Development Facilitation Team (DFT) – Review Comments

Project No: PR-2022-007520 Date: 01/17/2024 Agenda Item: #11 Zone Atlas Page: NR-LM

Application For: PS-2024-00002 – SKETCH PLAT

REQUEST: Vacate Existing 34 foot Railroad Easement

RAFAAR INVESTMENTS

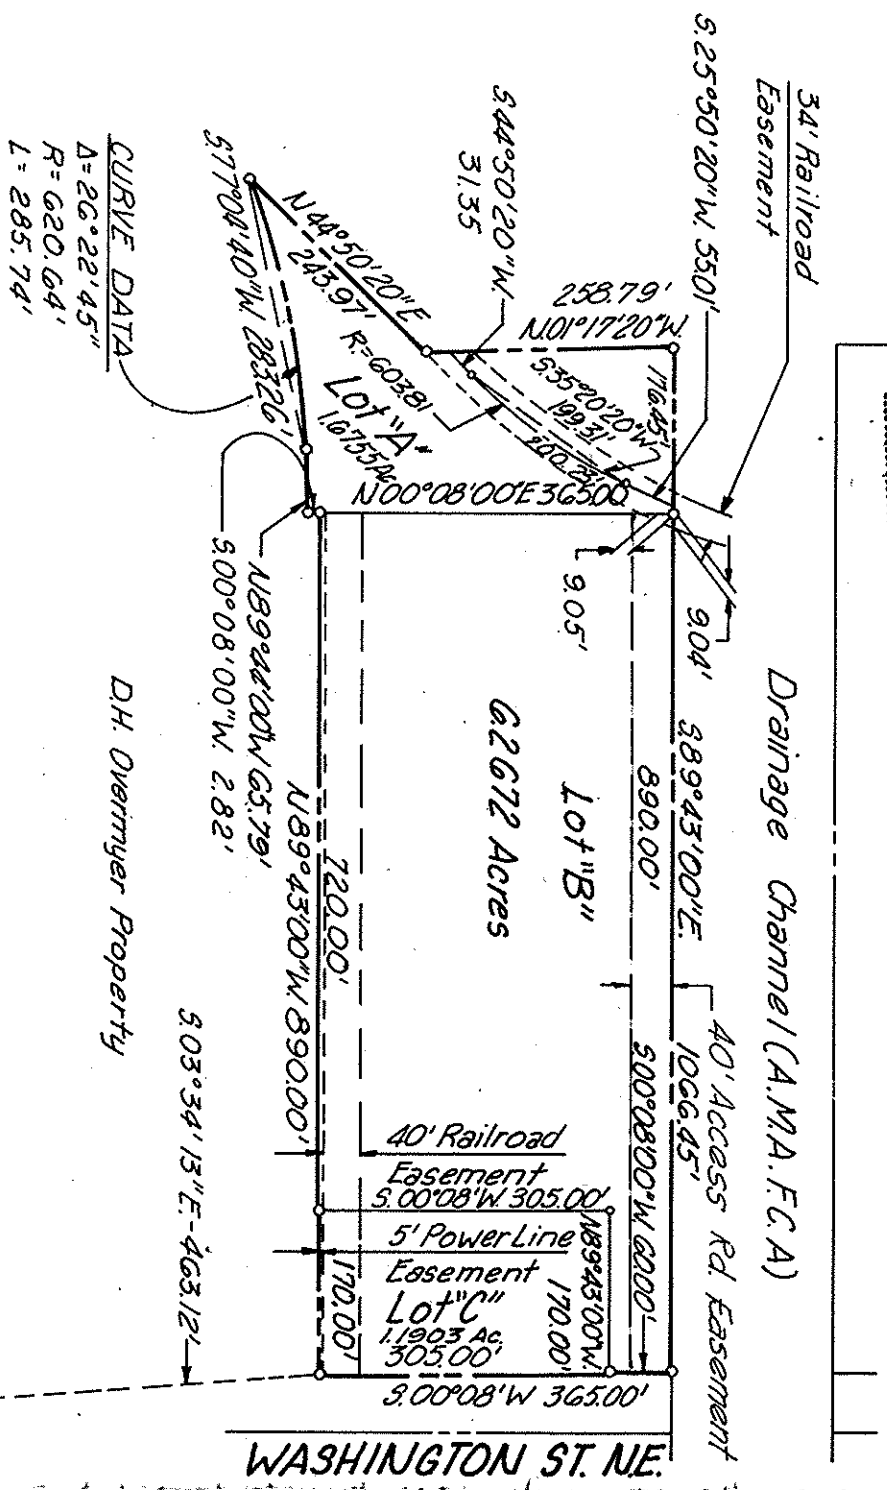
1. Availability Statement 220526 provided conditions to serve a hydrogen generation facility use and required public extensions. This statement is expired and will require a new one for any changes or to move forward with future proposed development.
2. The proposed plat is not changing the lot and is only for the proposed vacation therefore please only ensure to show how the statement requirements will be met for future development regarding easements.
3. No objections to the proposed vacation.
4. Please show all easements that are for public and private water and sanitary sewer.

1. Railroad easements are not under the jurisdiction of Transportation. Please provide documentation of ownership of the railroad and of their agreement to vacate this easement.
2. An approved TCL (Traffic Circulation Layout) will be required prior to site plan or Building Permit.

- Hydrology has sent a comment letter (C17D130) on March 7, 2022.
- Hydrology will need a notarized letter from the owner of the existing rail road easement stating that they are vacating their rail road easement.
- Hydrology needs to approve the Grading & Drainage Plan prior to the platting action.
